Arun District Council
Arun Civic Centre
Maltravers Road
Littlehampton
West Sussex BN17 5LF
Planning & Building Control General Enquiries
Tel: (01903) 737756 Fax: (01903) 730442
Dx: 57406 Littlehampton
Minicom: 01903 732765
e-mail: planning@arun.gov.uk
website: www.arun.gov.uk/planning

Application No: LU/214/20/PL
Site Address: Empty Supermarket Premises Avon Road Littlehampton BN17 6AT
Description of works: Demolition of existing buildings & redevelopment comprising 50 No. residential units (Class C3) & flexible commercial floorspace (Class A1, A2, A3 and/or D1) together with the provision of car & cycle parking, landscaping & associated works (resubmission following LU/3/19/PL). This application affects the setting of listed buildings & may affect the character & appearance of the East Street, Littlehampton Conservation Area. This application is in CIL Zone 4 (Zero Rated) as 'flats & other development'.

Thank you for your internet representation made on 14th September 2020 which has been recorded as an objection with the comments as follows:

Drawing Title
**EXISTING
ELEVATION B**

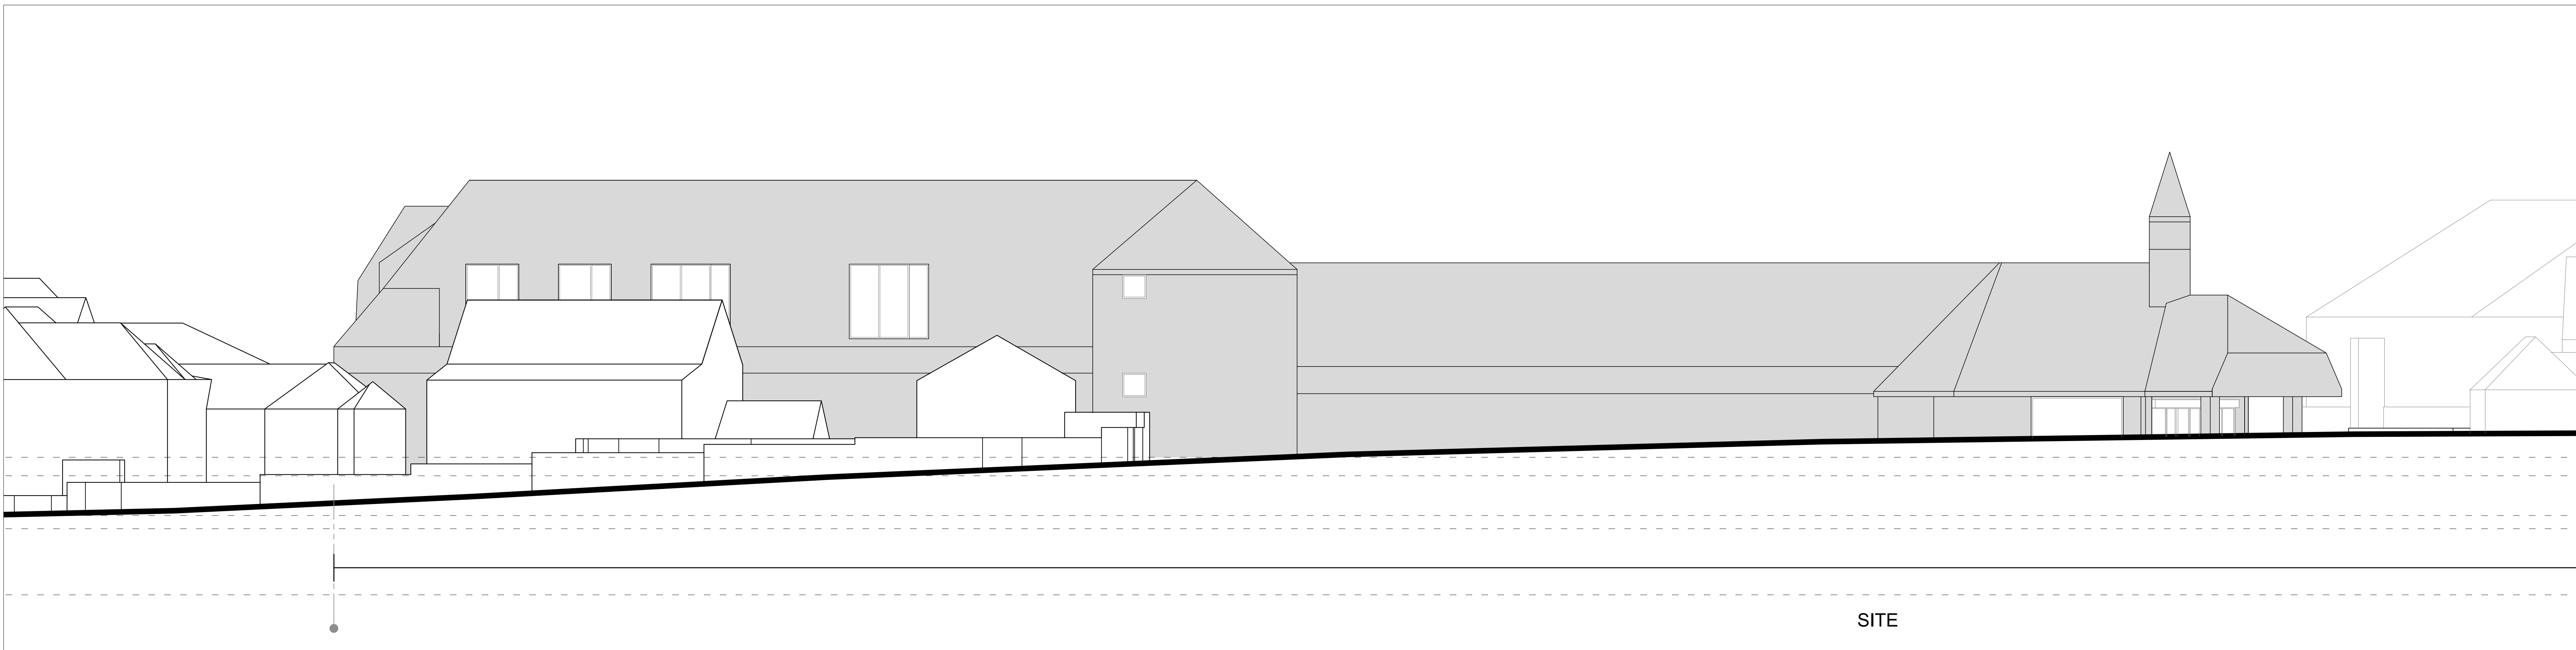
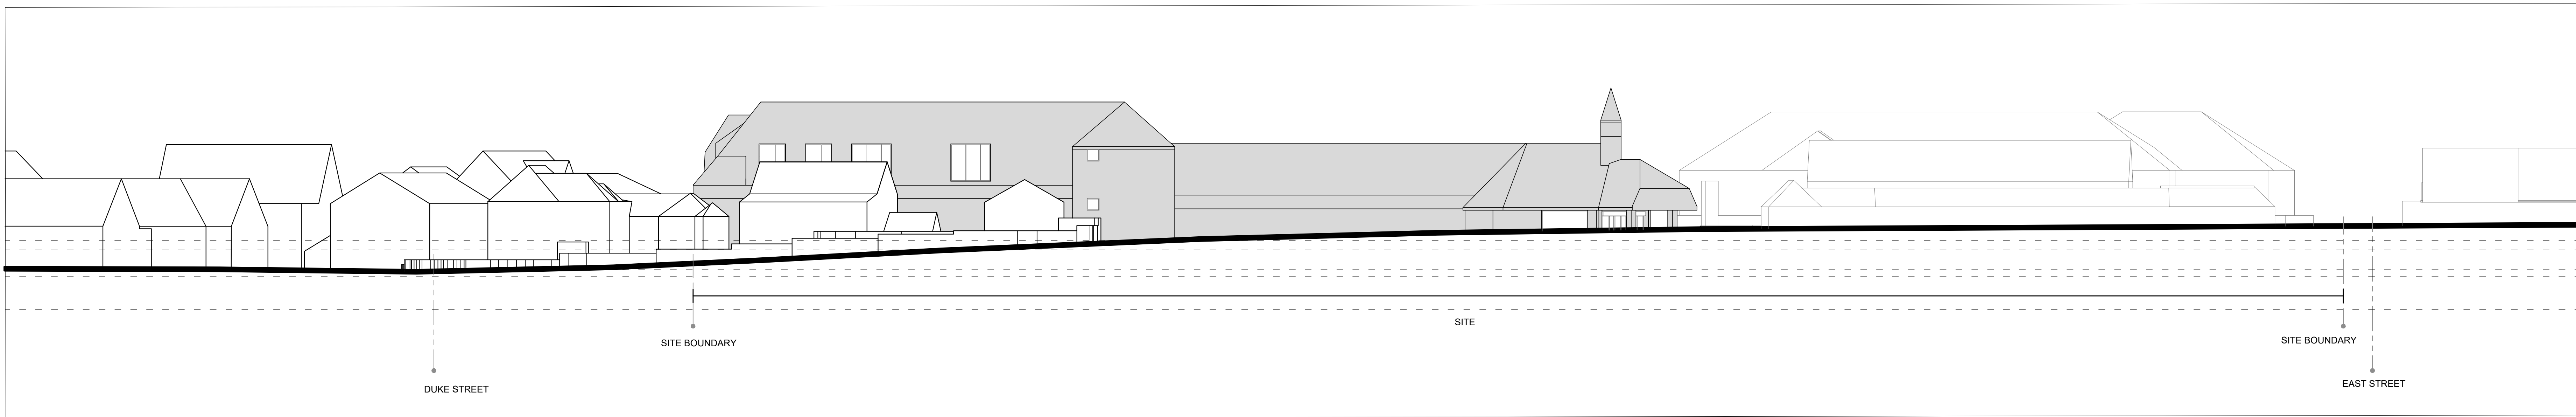
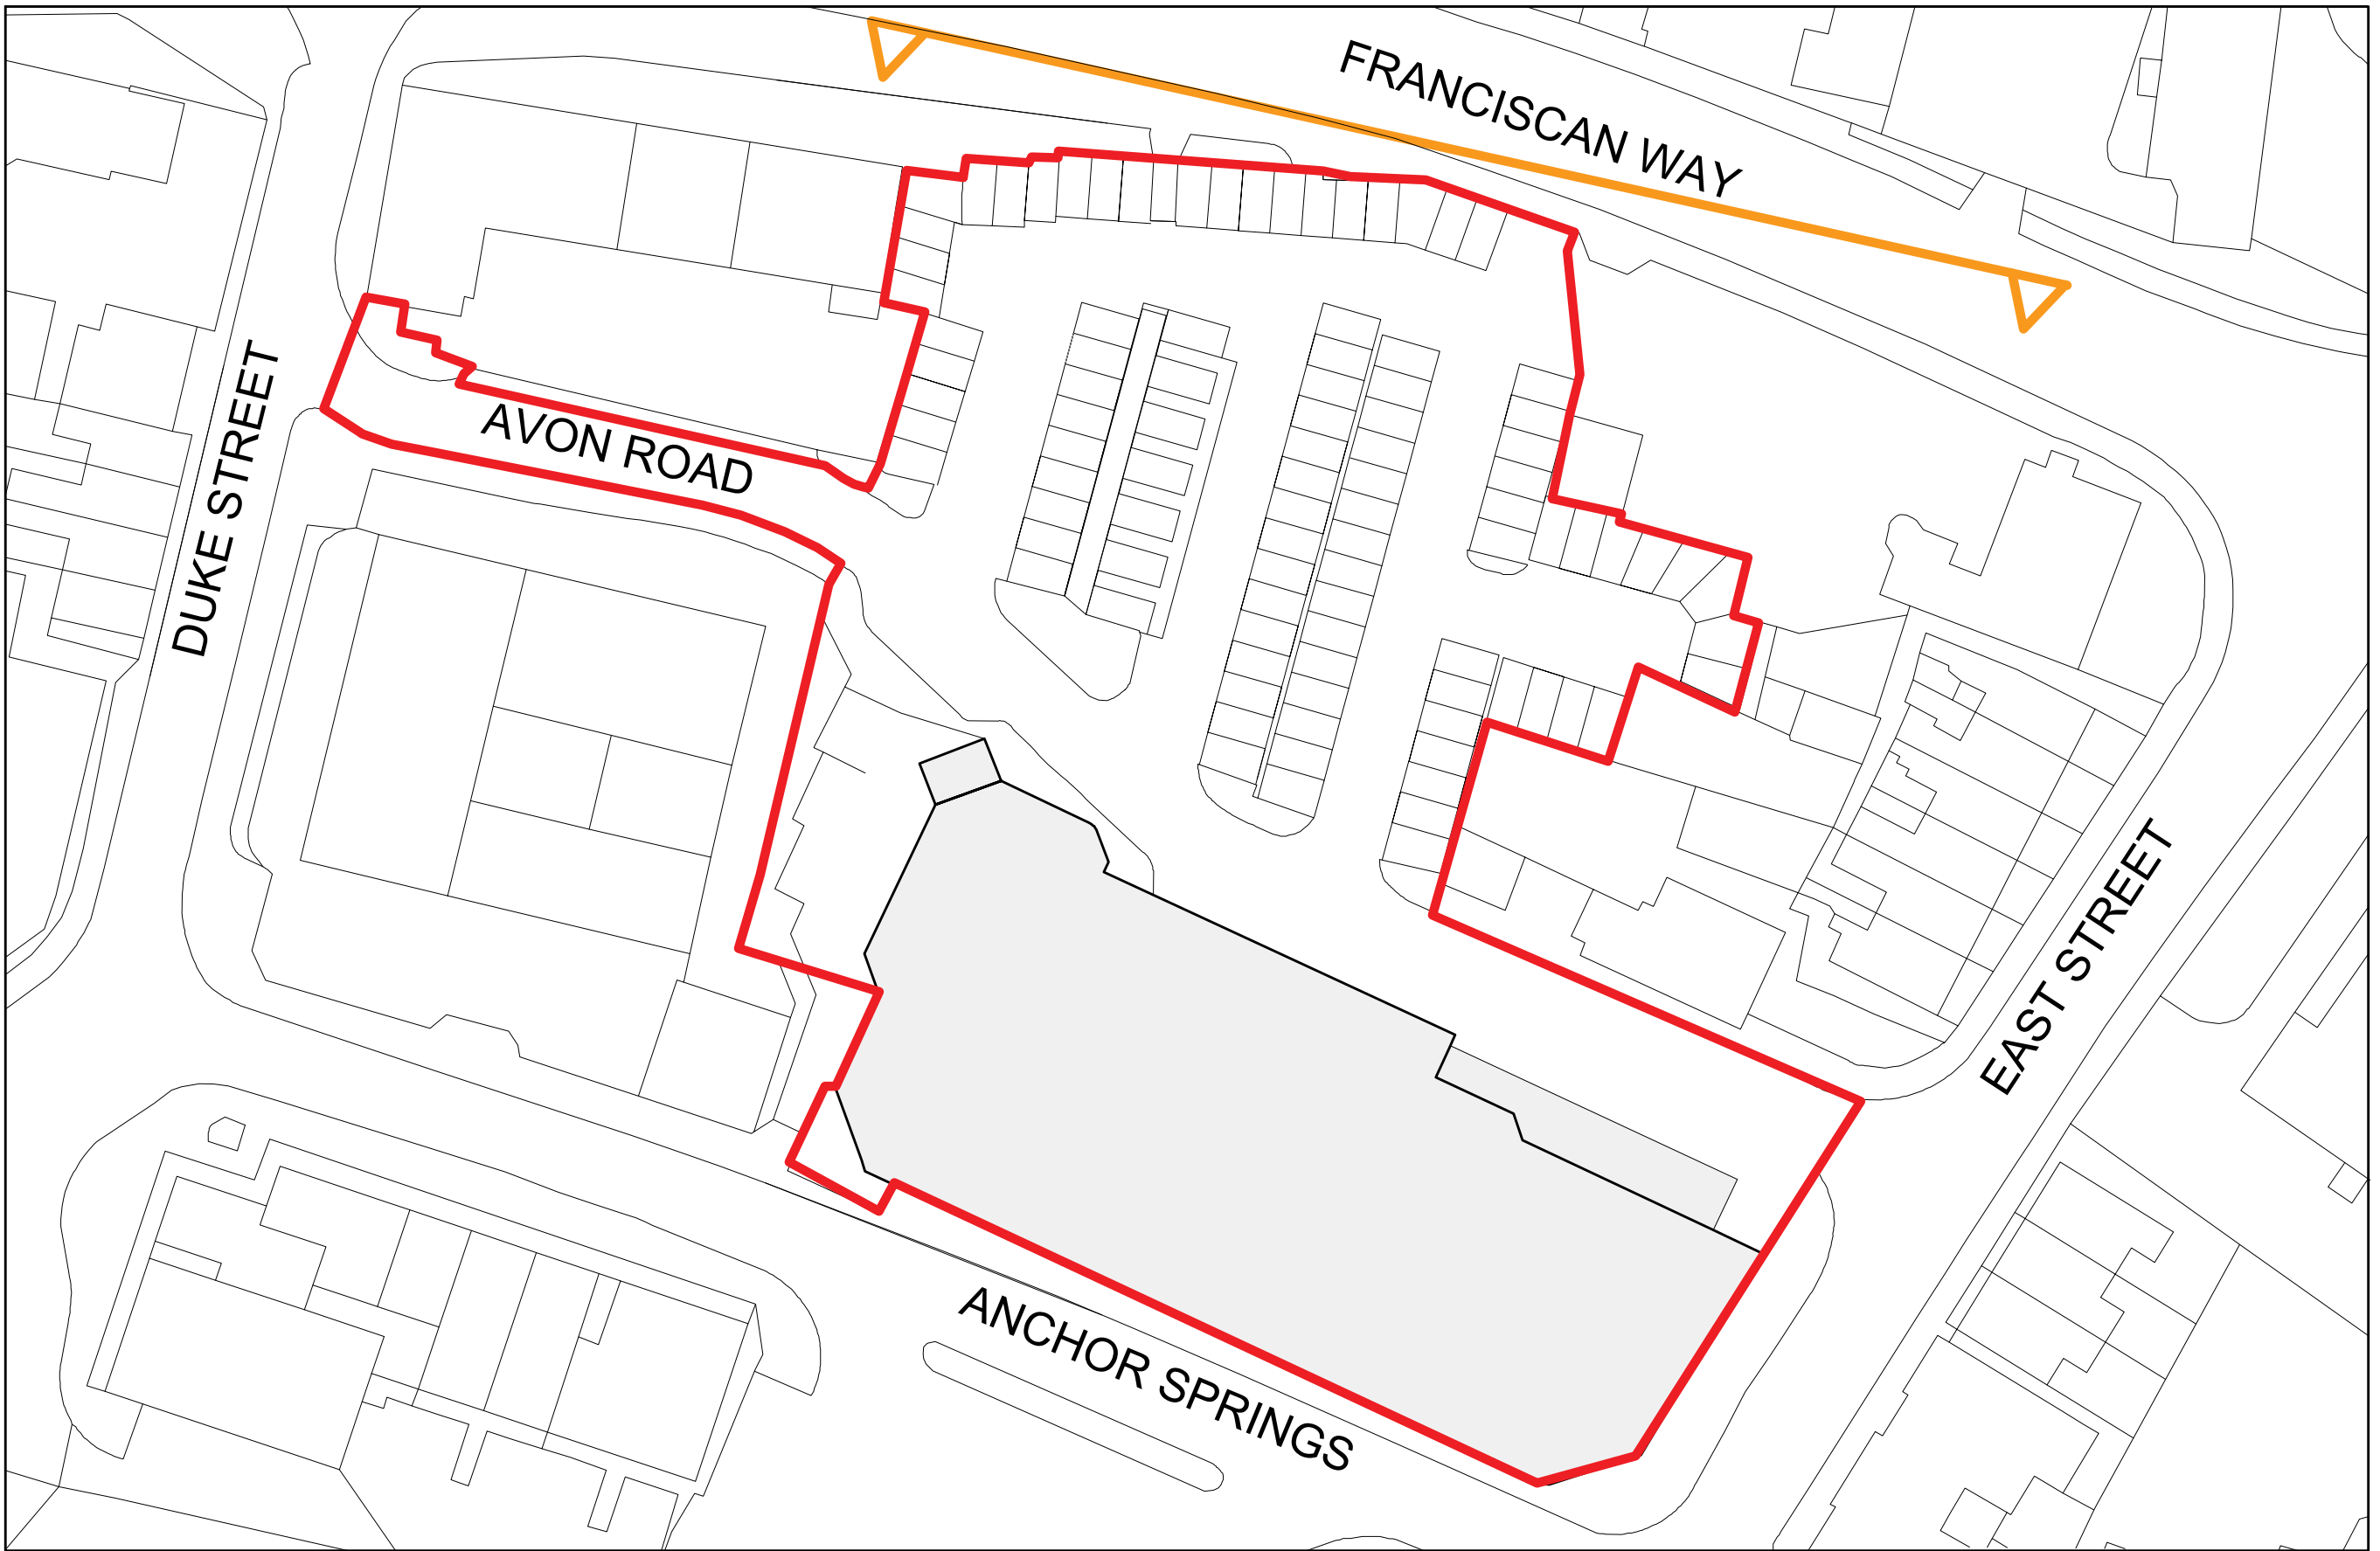
- Existing Elevation B

- East St and Duke St are wrong way round
